Bramford to Twinstead Reinforcement

Document 8.5.10: Applicant's Comments on Submissions Received at Deadline 2

October 2023

Planning Inspectorate Reference: EN020002

STOUR VALLEY EAST  
 CABLE SEALING END  
 COMPOUND AT LITTLE  
 CORNARD

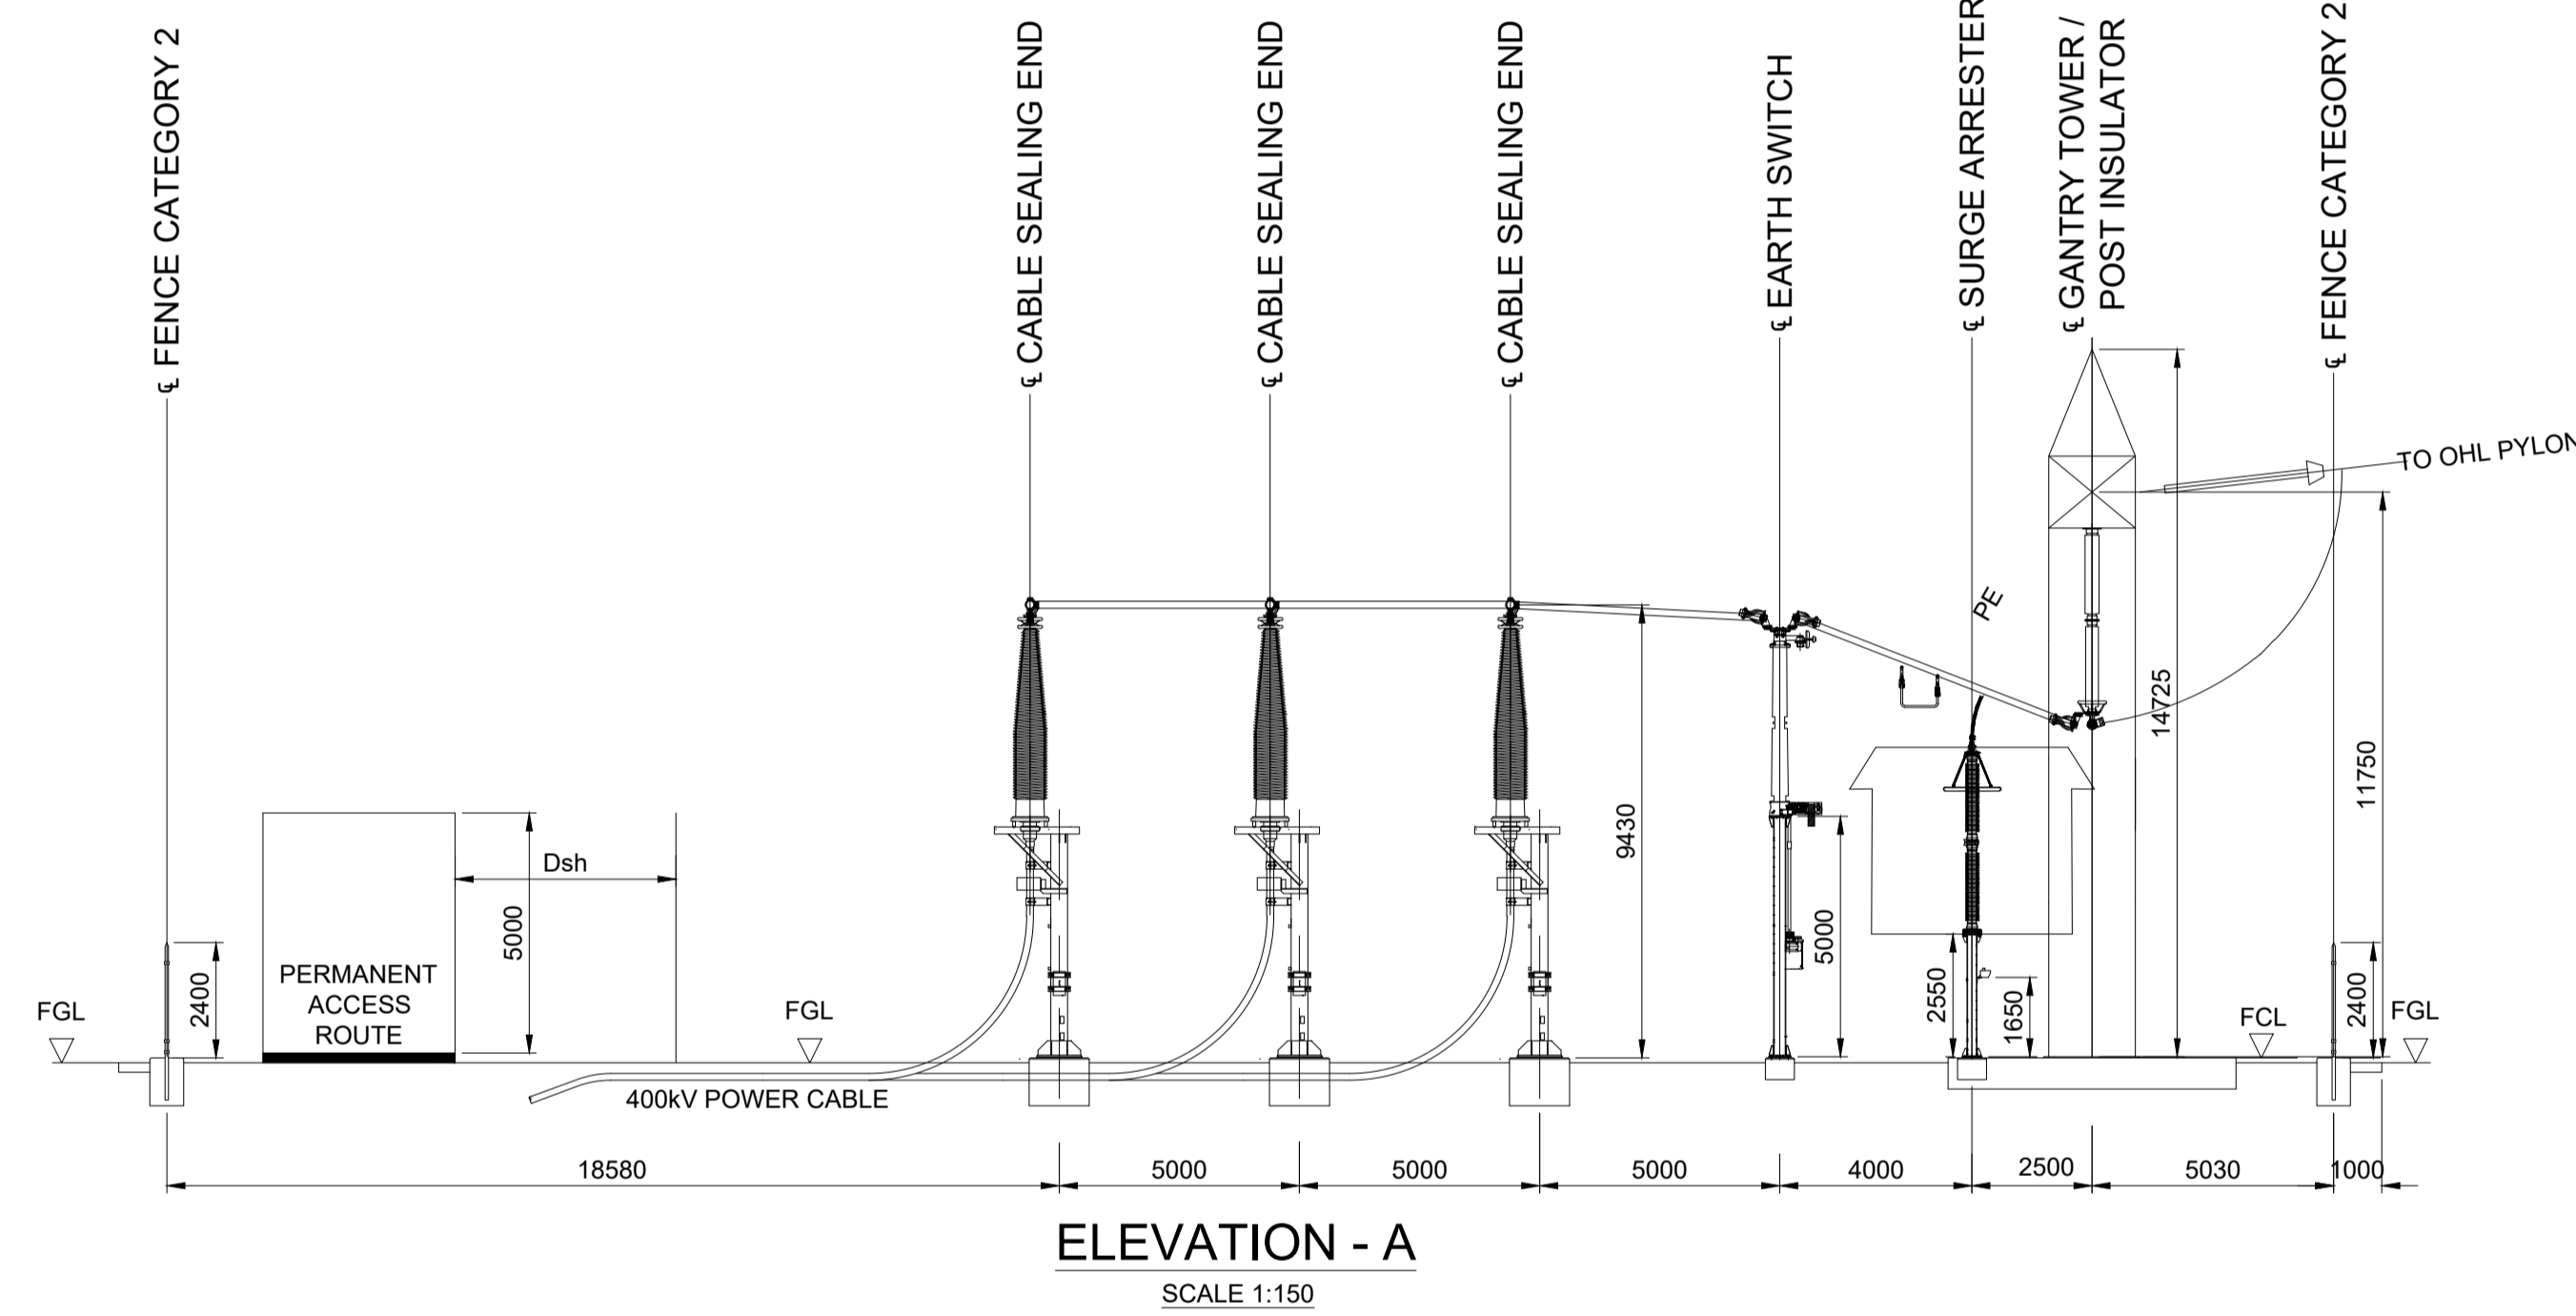
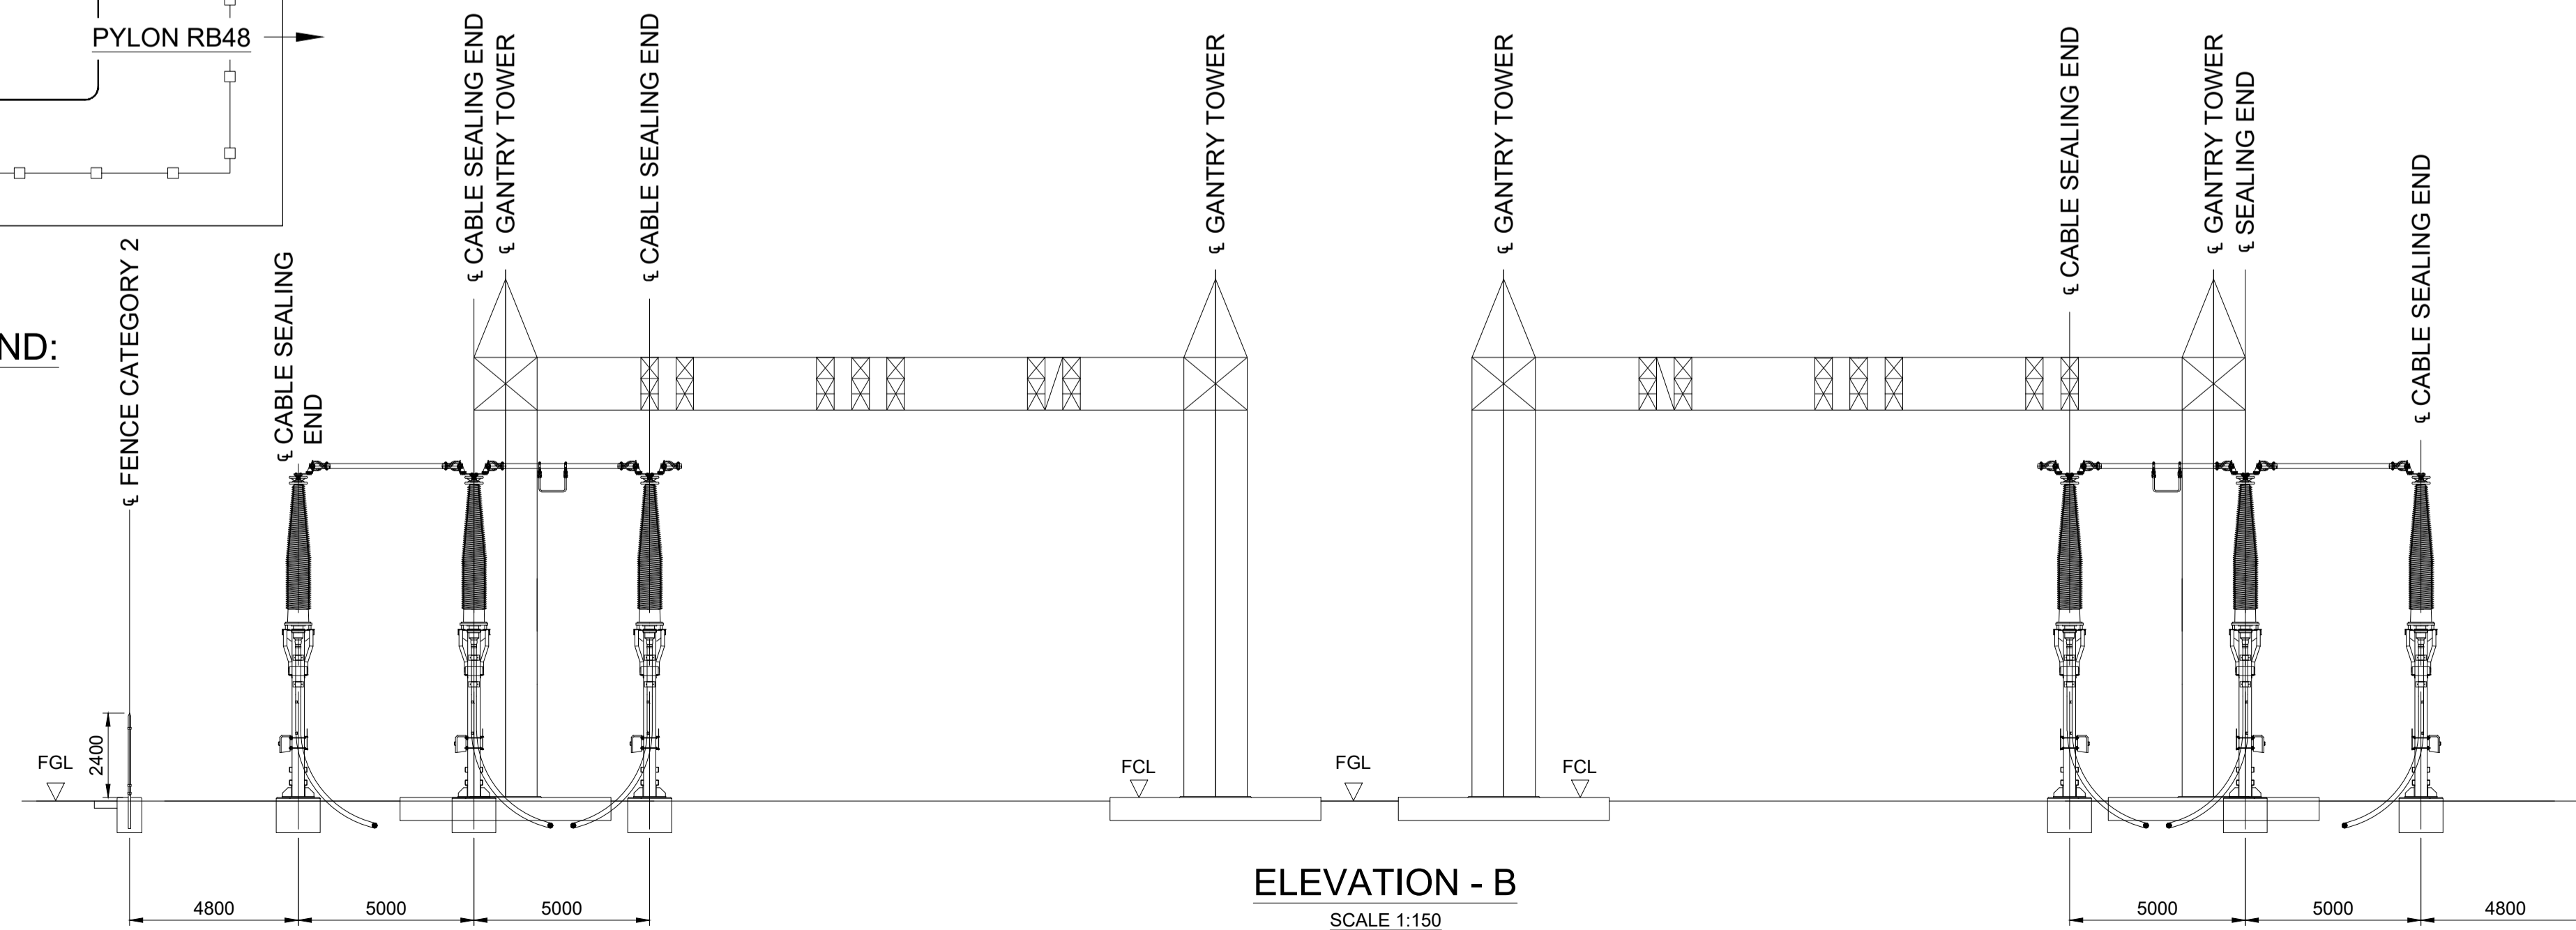
4.10	Stour Valley East CSE compound	BDC welcomes the additional undergrounding in the Stour Valley. The Council retains concerns that the assessment of the Stour	The Applicant has responded to these points in Chapter 2 of the Applicant's Comments on Babergh Mid Suffolk District

Reference	Matter	Point Raised	Applicant's Comments
		Valley East CSE compound has been considered at some distance from the facility therefore does not fully consider the experience of sensitive receptors using the PRoW network close by. As a result, there are concerns that any proposed mitigation or compensation will be insufficient to offset these anticipated adverse effects. BDC would like to see further assessment carried out from the PRoW network close to the facility and provision of a demonstrably effective mitigation and/or compensation scheme.	Council Additional Local Impact Report (document 8.5.3.3) and has no further comment to make at this stage.
